Development Control
Ribble Valley Borough Council

App no: 24.0667

Address: Ground floor Unit 5b Abbey Works King Street Whalley

Proposal: Regularisation of unauthorised addition of mezzanine floor and creation of bar/cafe upstairs

Location Plan

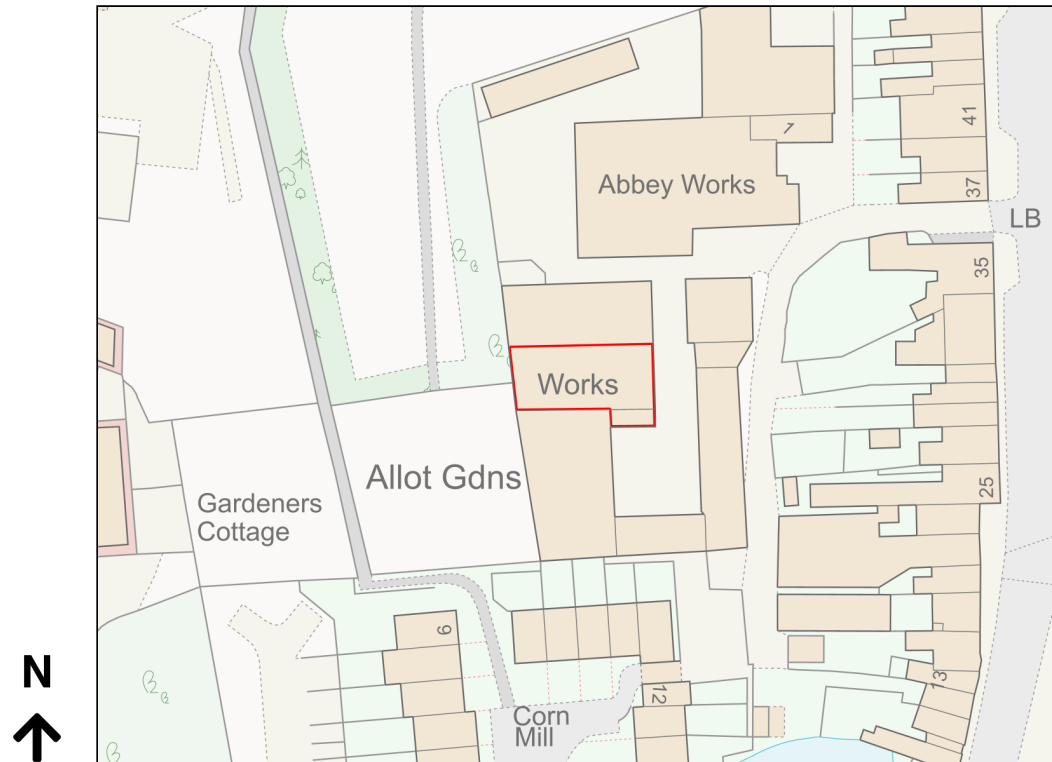
We would request that the access up to King Street and the car parking associated with the building is included in the red edge.
